CITY OF ALBUQUERQUE

Re: Apartments at 633 Adams Street NE, Traffic Circulation Layout
Architect's Stamp dated 11-14-09 (J17-D032)

**Re: 633 Adams St NE, New Building Grading and Drainage Plan
Engineer's Stamp dated 3-3-10 (J17/D032)**

**Re: Apartments at 633 Adams Street NE, Traffic Circulation Layout
Architect's Stamp dated 10-26-09 (J17-D032)**

SCALE: N/A

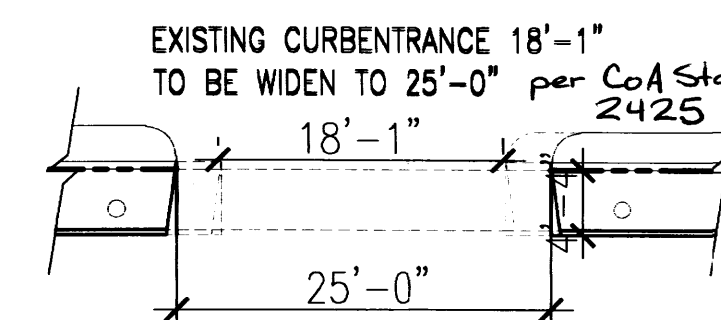
1. Build notes, referring to specific City of Albuquerque standards, must be provided for all items proposed within the right of way.
2. The handicapped space must include an 8-foot wide van access aisle.
3. Provide a legend defining all linetypes.
4. Clarify what portion of the parking areas are unpaved, and which are paved.
5. An ADA accessible pathway must be maintained from the handicapped parking stall(s) to the building. The ADA accessible pedestrian pathway must be a minimum of 6 feet wide. Please clearly detail this area; is the proposed sidewalk flush with the pavement? If not, a wheelchair ramp will be required.
6. Provide details for all wheelchair ramps; define the maximum slope.

1. Geometric information, such as aisle widths, parking stall dimensions, widths of all entrances, and the width of the existing sidewalk, must be provided. A full review cannot be completed without this information.

2. Please show the location of the nearest driveways on each adjacent lot. Proposed curb cuts must be located at least 22 feet from these existing curb cuts.

3. Clarify the proposed modifications to the existing curb cut. Define the existing and proposed width.
4. List radii for all curves shown; for passenger vehicles, the minimum end island radius is 15 feet.

5. Build notes, referring to specific City of Albuquerque standards, must be provided for all items proposed within the right of way.
6. The proposed parking spaces as shown along Adams Street are unacceptable. Please see the *Development Process Manual*, Chapter 23, Section 6, Part B.8.b.2, which states, "No backing from designated parking stalls into the streets is permitted." This parking stall layout is acceptable along the alleyway, due to the low traffic volume.

7. Please show a vicinity map.
8. Clearly demonstrate the 6-foot wide, ADA accessible, pedestrian pathway from the roadway to the building.
9. List the number of parking spaces required by the zoning code as well as the proposed number of parking spaces.

10. Two different scales are shown on the plan, $\frac{1}{4}''=1'$, and $1''=20'$. Neither of these scales is accurate. Please revise the drawing to be shown at a scale of 1 inch equals 20 feet.

11. Provide details for all wheelchair ramps; define the maximum slope.
12. An ADA accessible pathway must be maintained from the handicapped parking stall(s) to the building. The ADA accessible pedestrian pathway must be a minimum of 6 feet wide.

GRADING & DRAINAGE

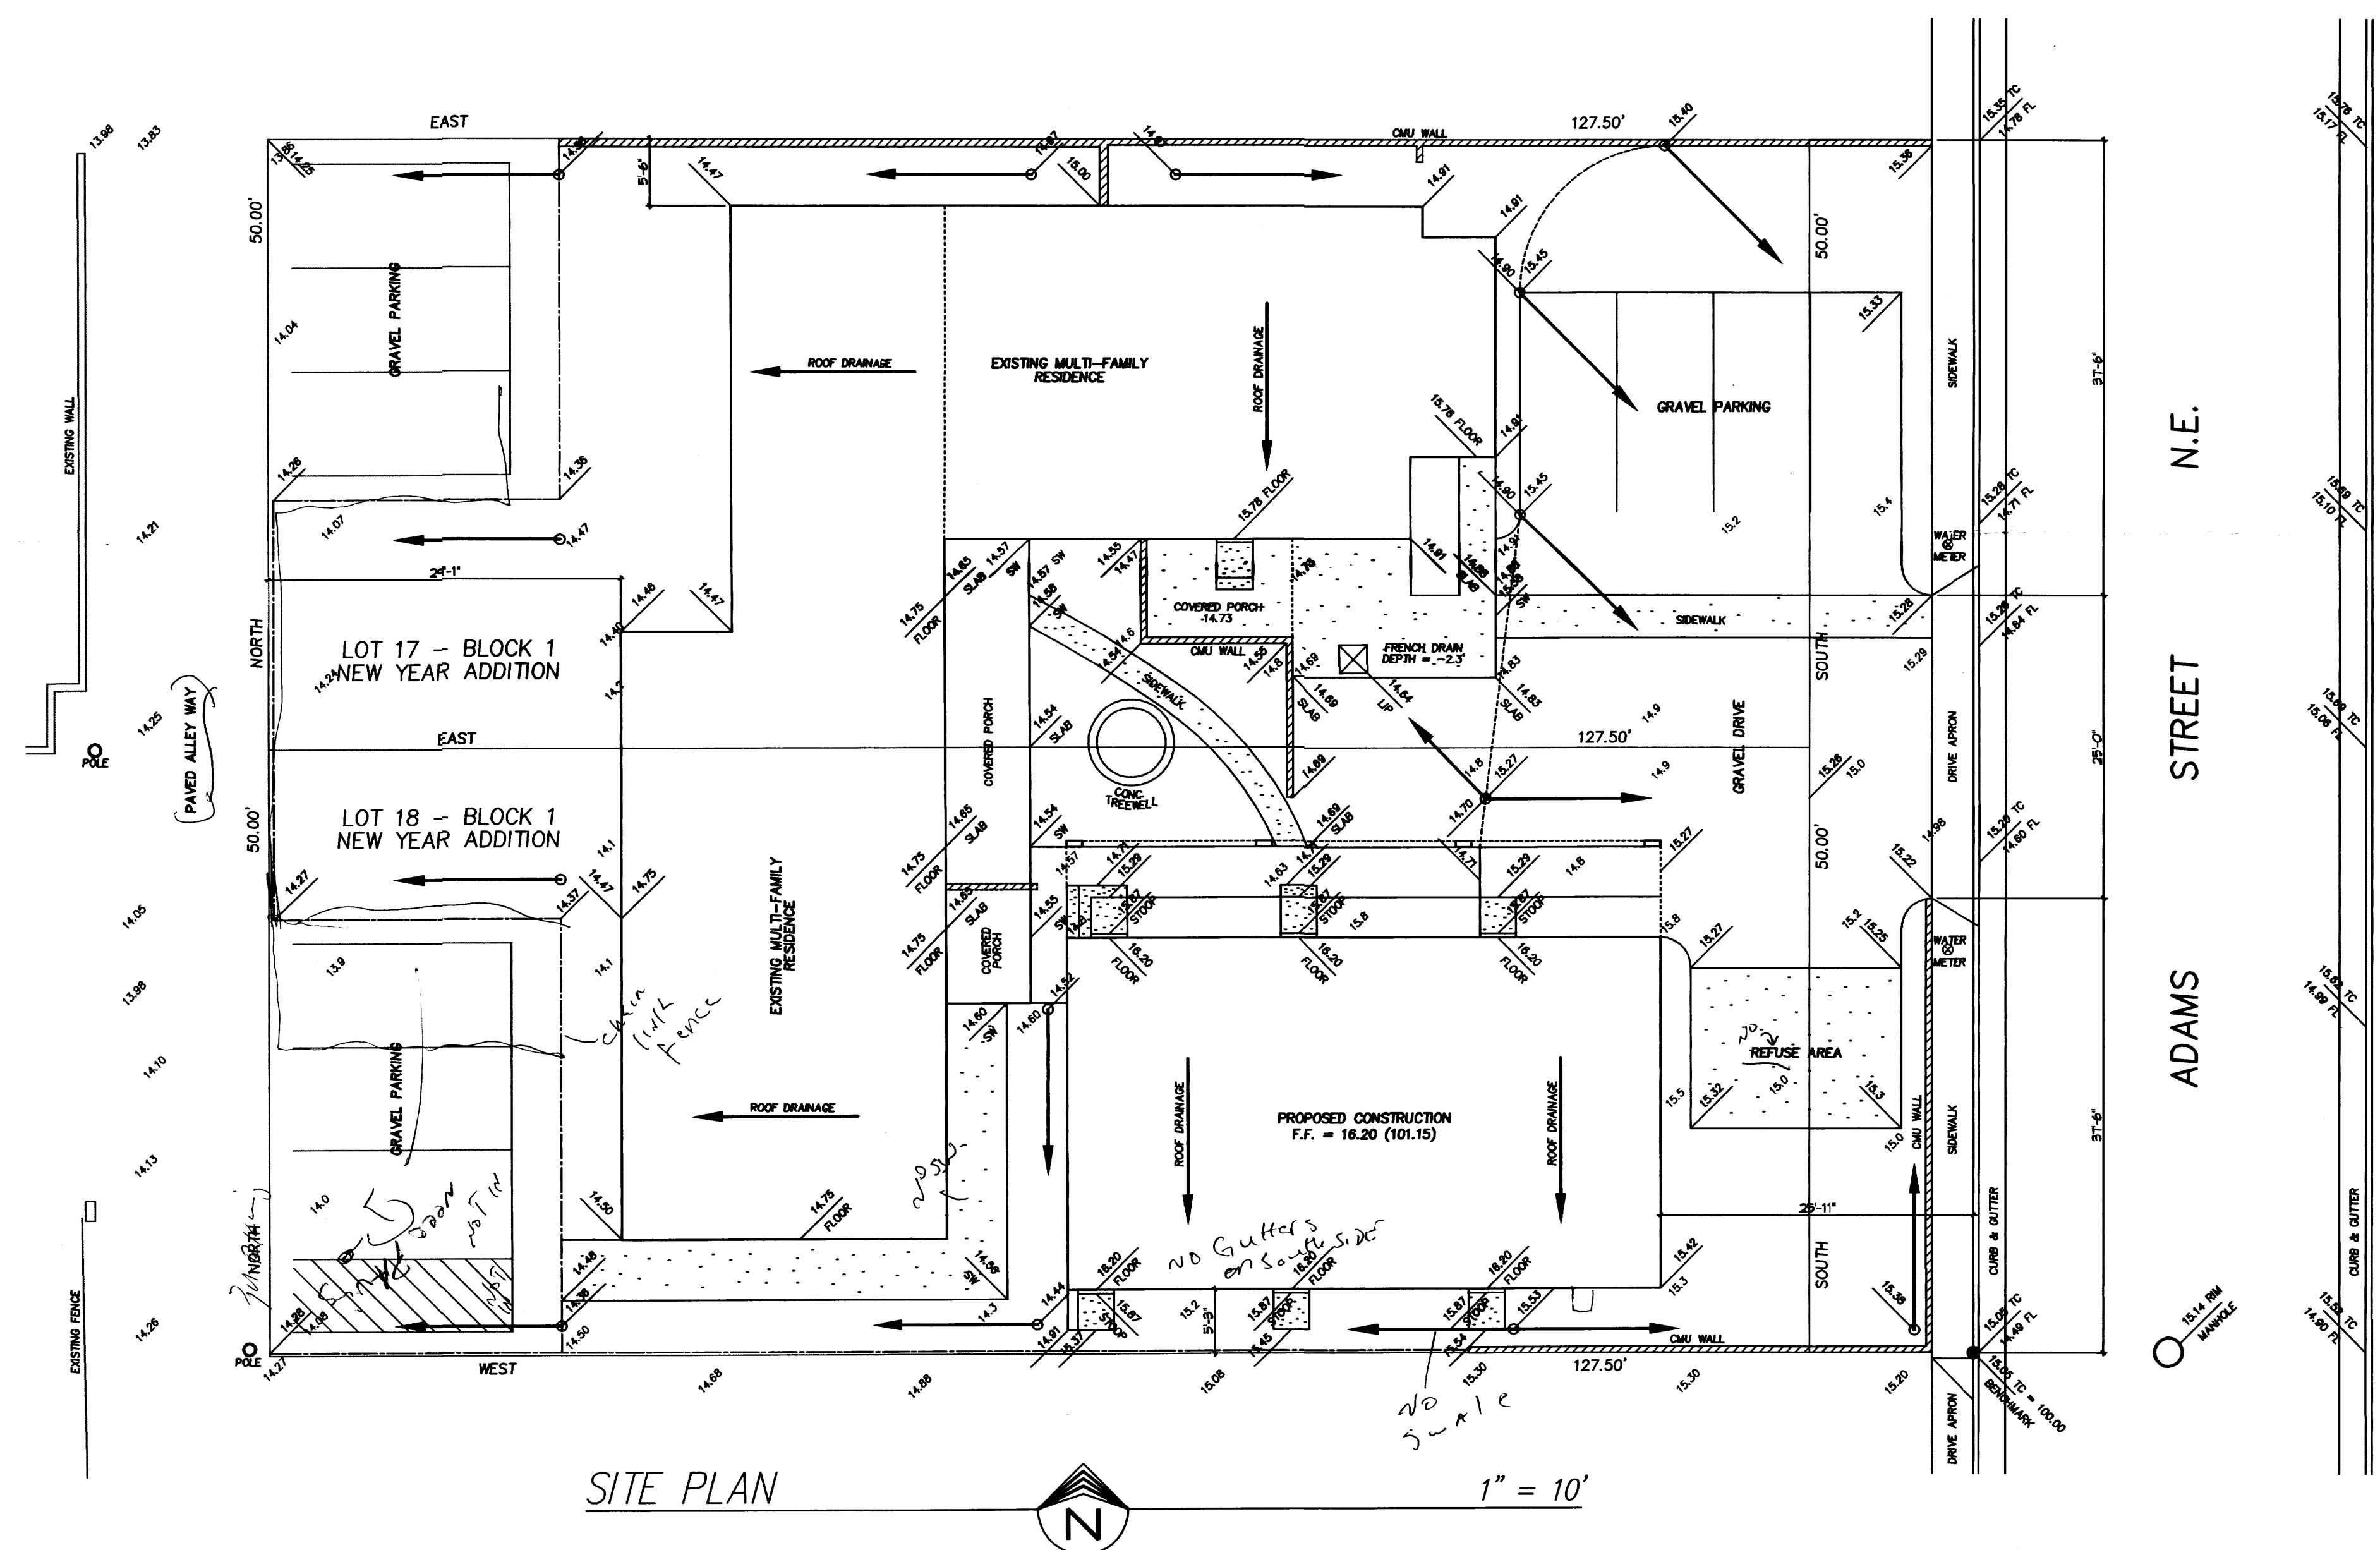
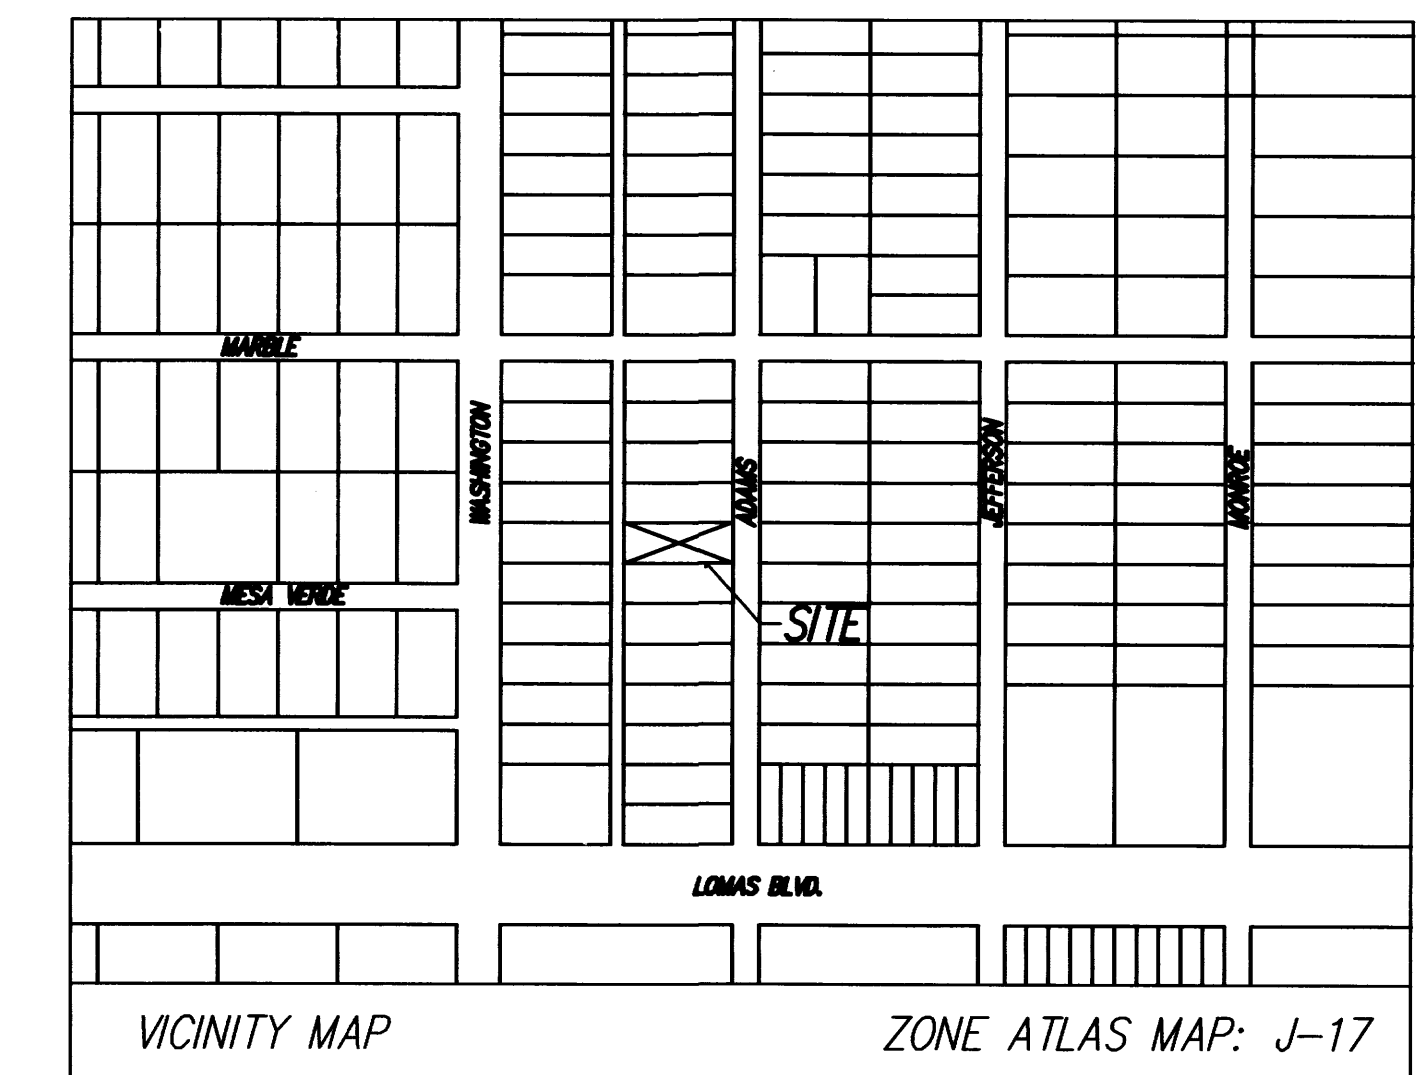
Based upon the information provided in your submittal received 3-5-10, the above referenced plan is approved for Building Permit with the condition that a gutter/downspouts be built on the south side of the roof. I annotated this condition on the Building Permit set. Please attach a copy of this approved plan to the construction sets prior to sign-off by Hydrology.

For future reference, flow rate (cu ft/sec) calculations are required on Grading and Drainage plans.
